CITY OF PORTLAND

Located At 24 TORREY ST

Job ID: 2011-07-1749-SF

has permission to build a new Single Family Residence.

**PROJECT NO:** 1101  
**ISSUED:** 07.20.11  
**DRAWN BY:** CMB  
**CHECKED BY:** ---  
**SHEET TITLE:**  
 Roof Framing Plan

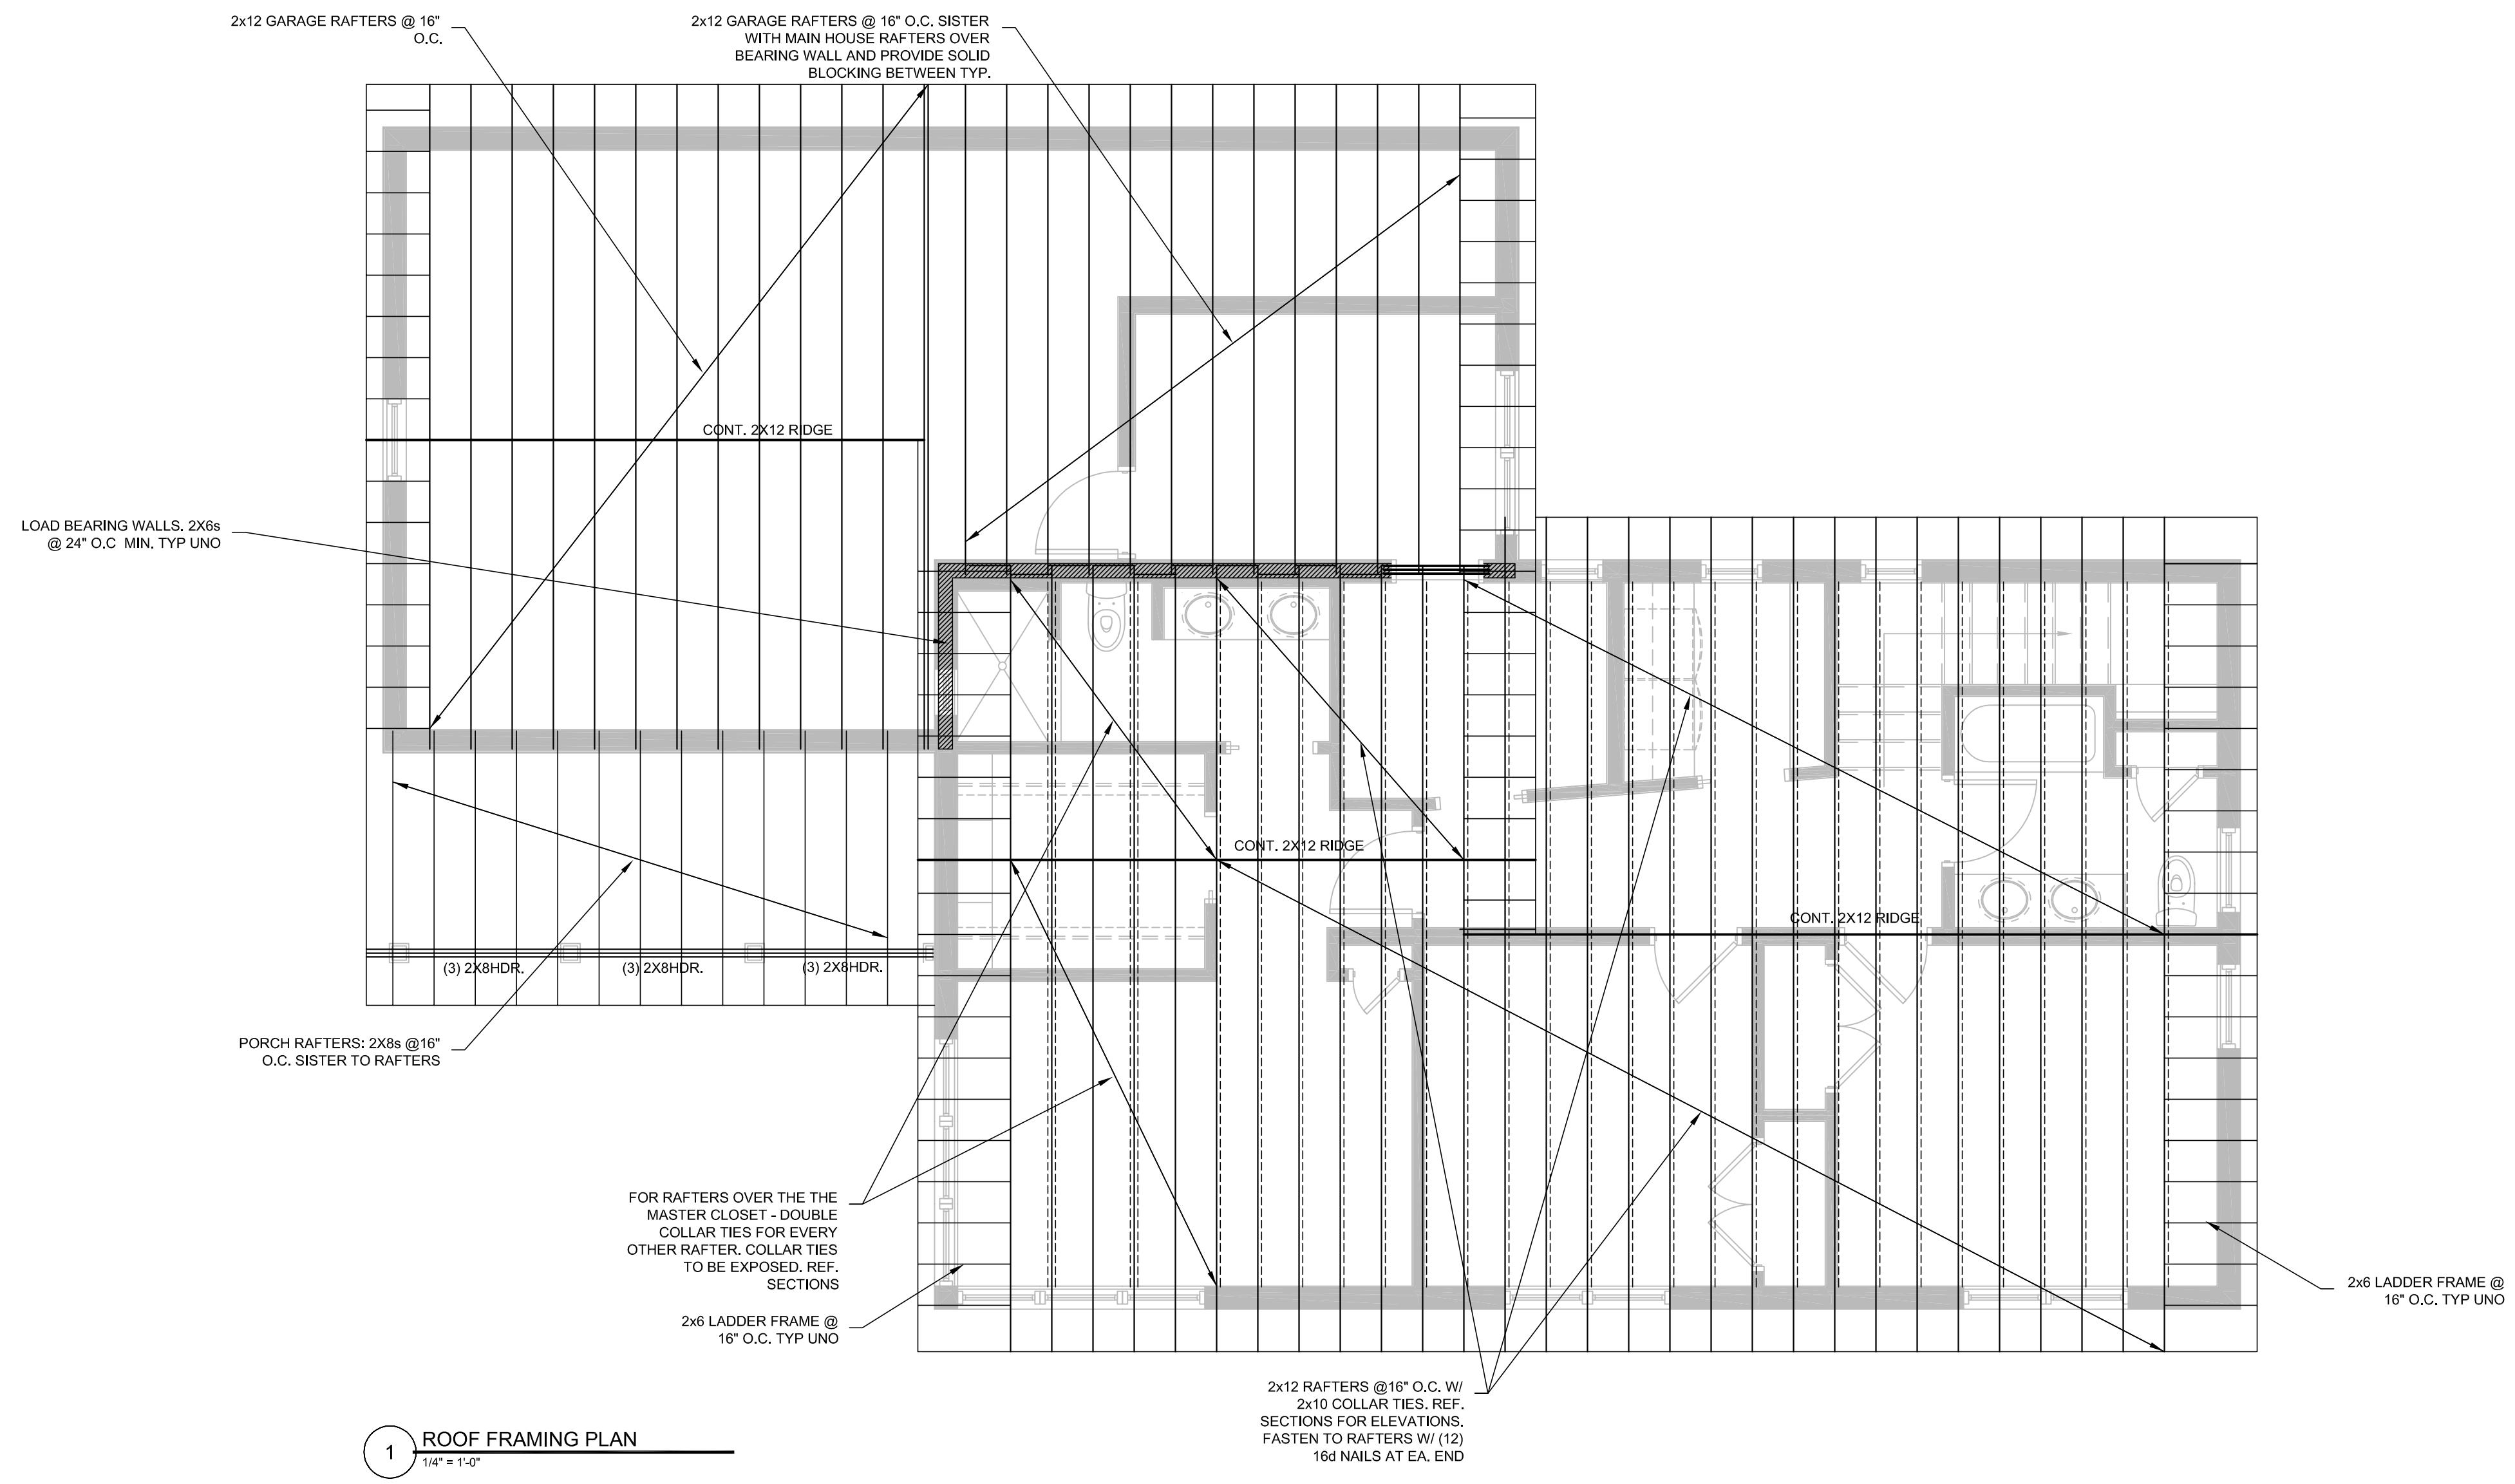
What is the roof pitch, & Connections (Section R802.3 & R802.3.1)

The Roof is a 12:12 pitch. The rafters are connected to the top plate w/ Simpson hurricane clips. The collar ties are fastened with a minimum of (6) 16d nails at each end.

A2

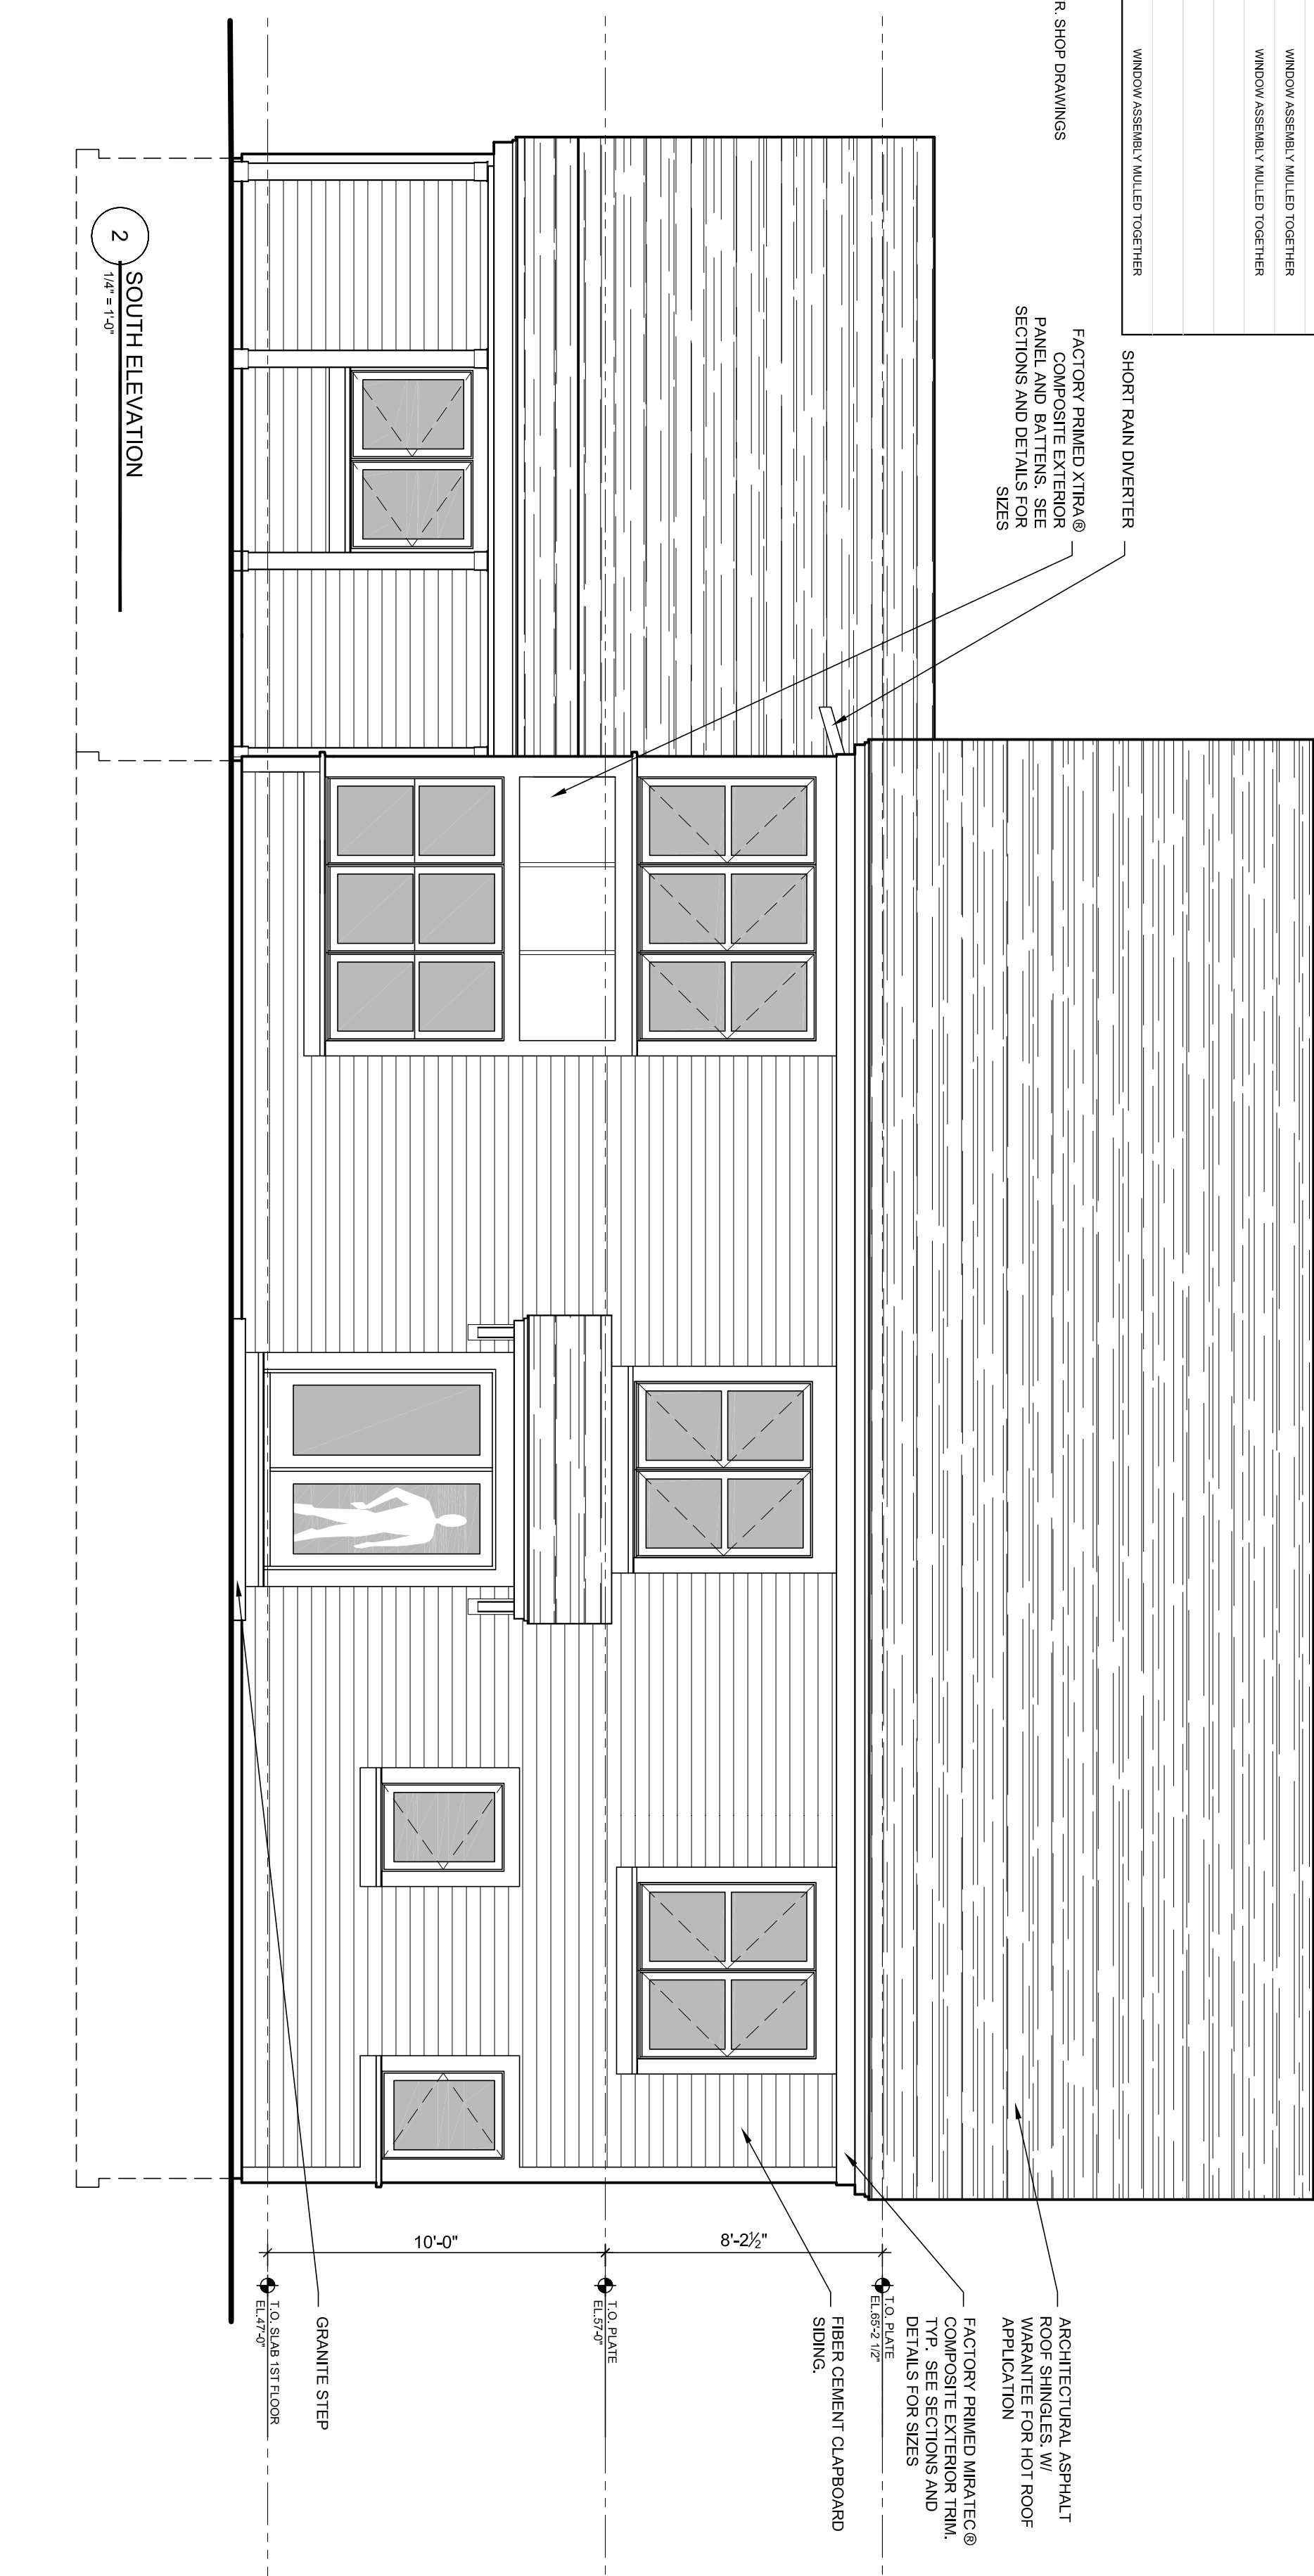
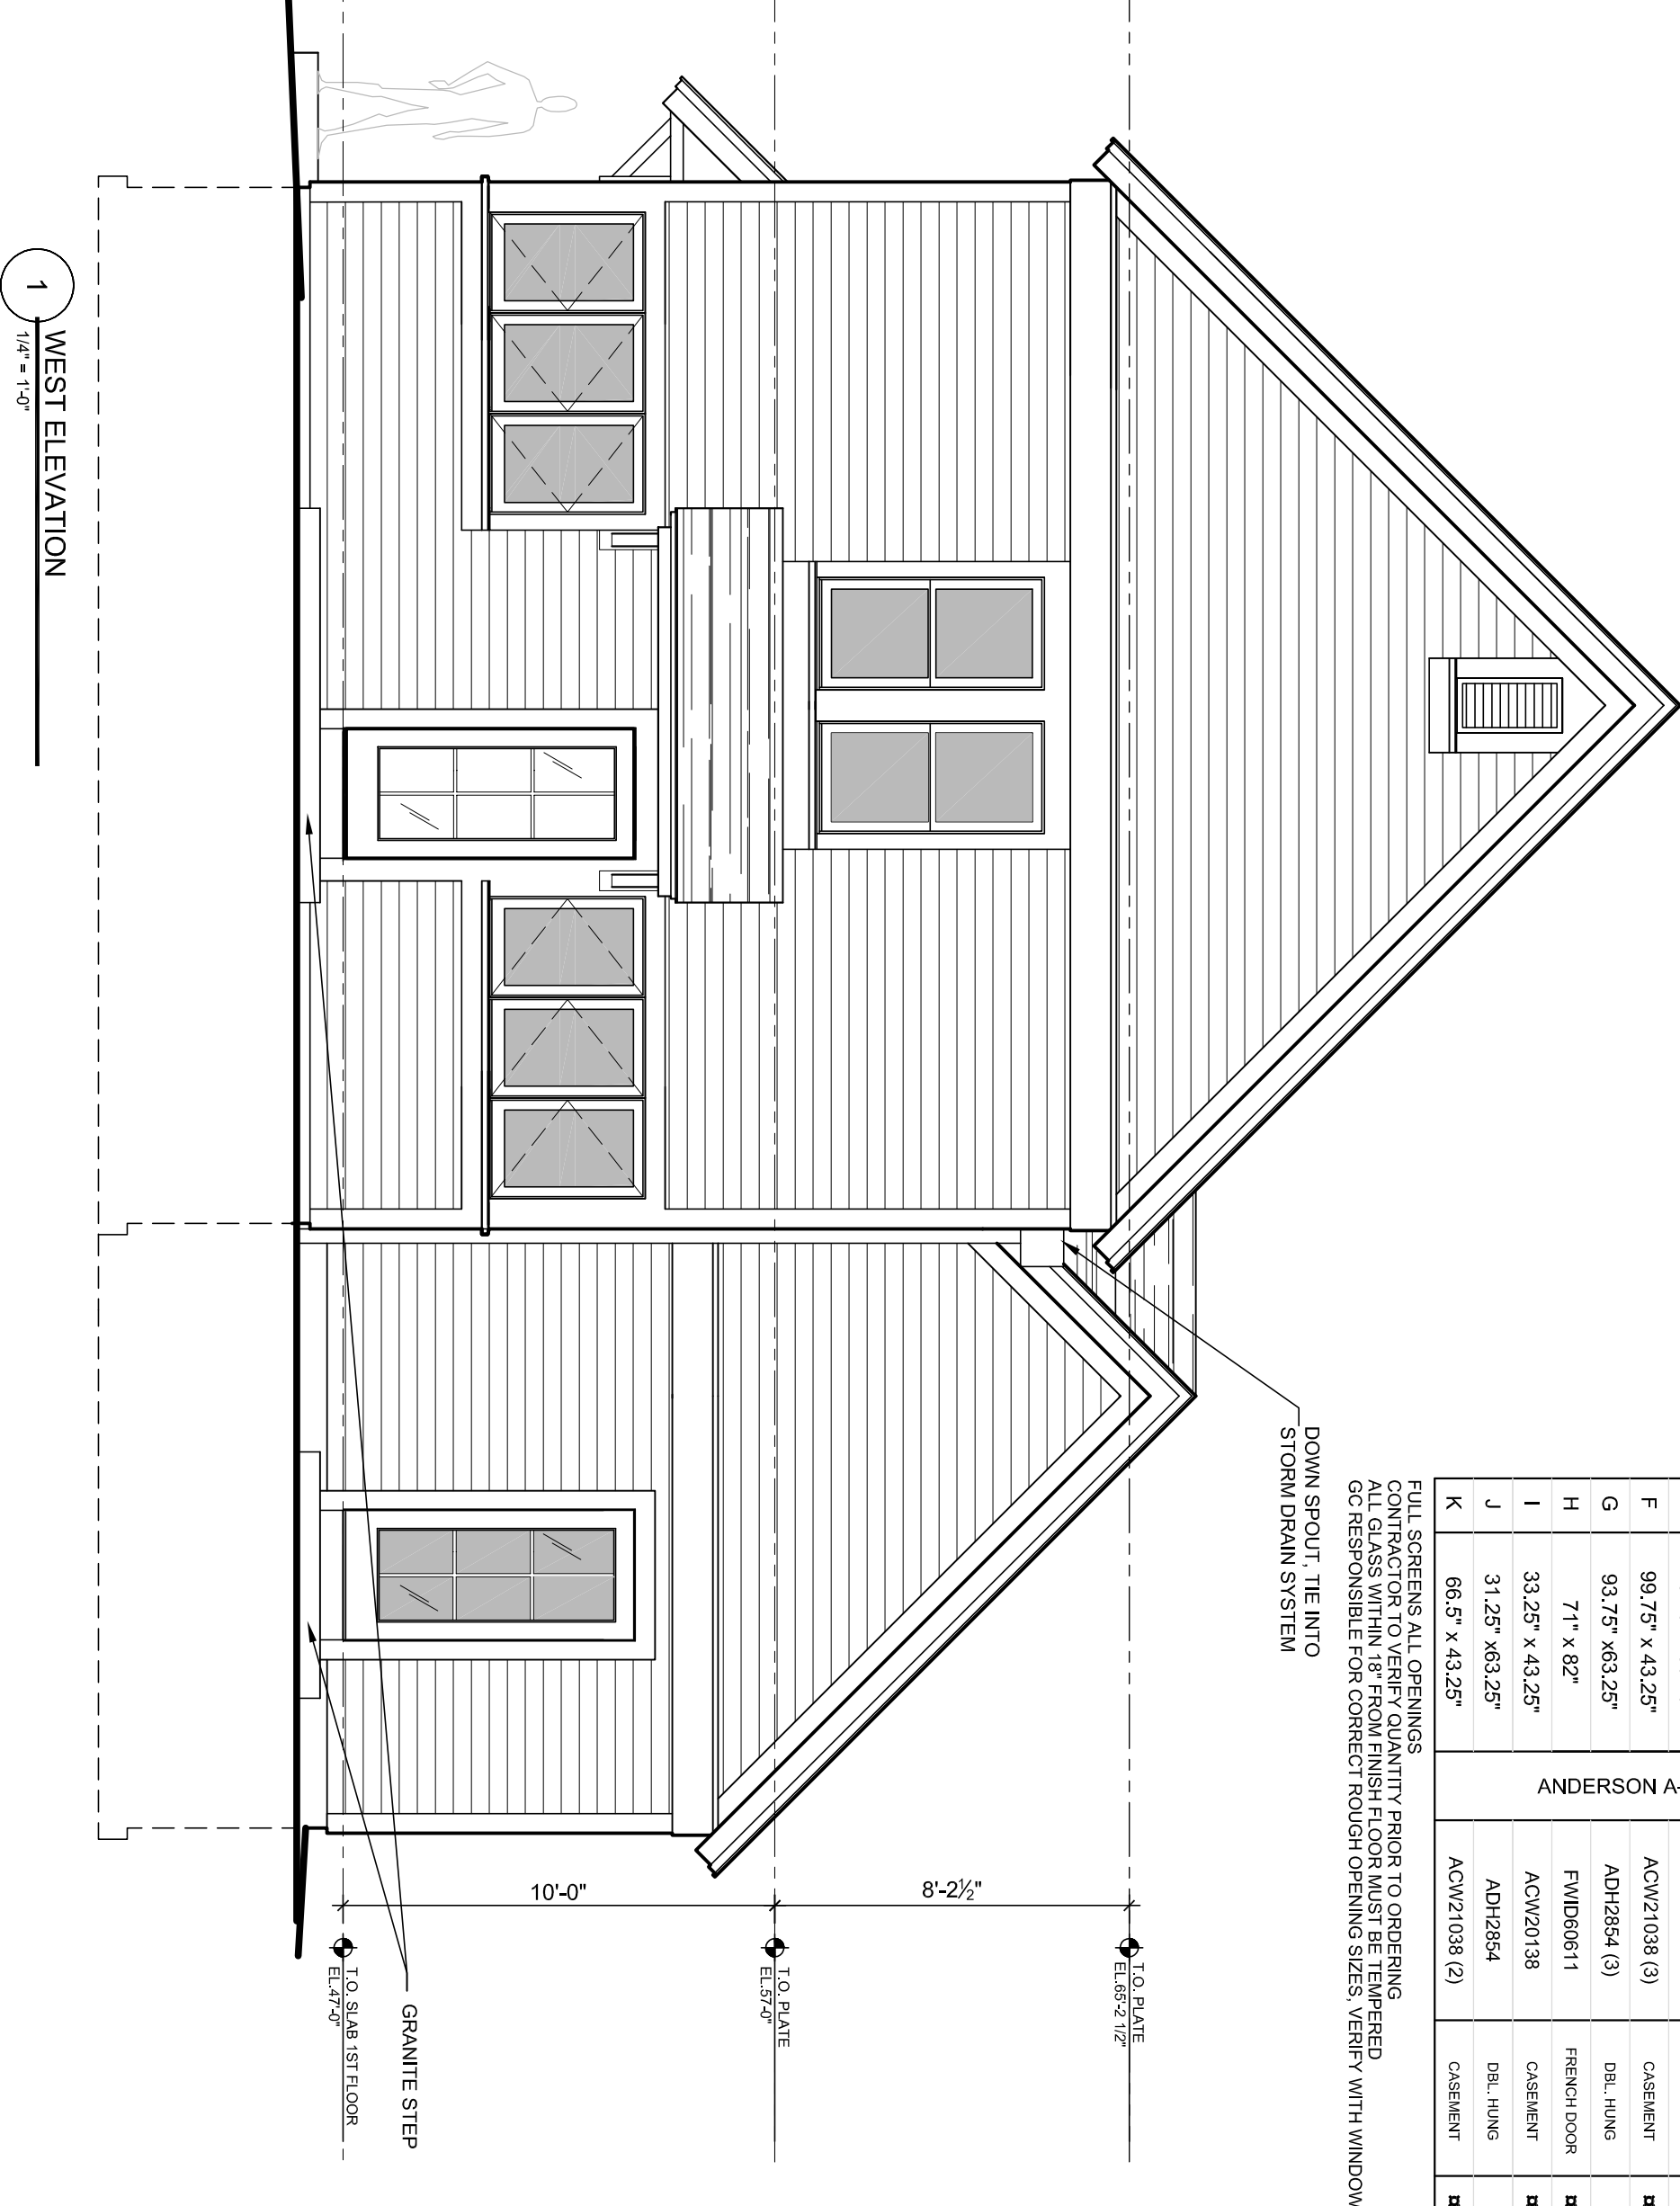
Windows:

- Window sills in locations more than 72 inches from finished grade shall be a minimum of 24 inches above the finished floor of the room, unless a window fall prevention devices is installed in accordance with section R612.3.
- A code compliant emergency escape shall be provided in the bedroom. Window sills in locations more than 72 inches from finished grade shall be a minimum of 24 inches (no higher than 44 inches) above the finished floor of the room.

We will be raising the 2nd floor windows by two inches to ensure their will be >24" above the finished floor. All bedrooms have windows that meet egress requirements.
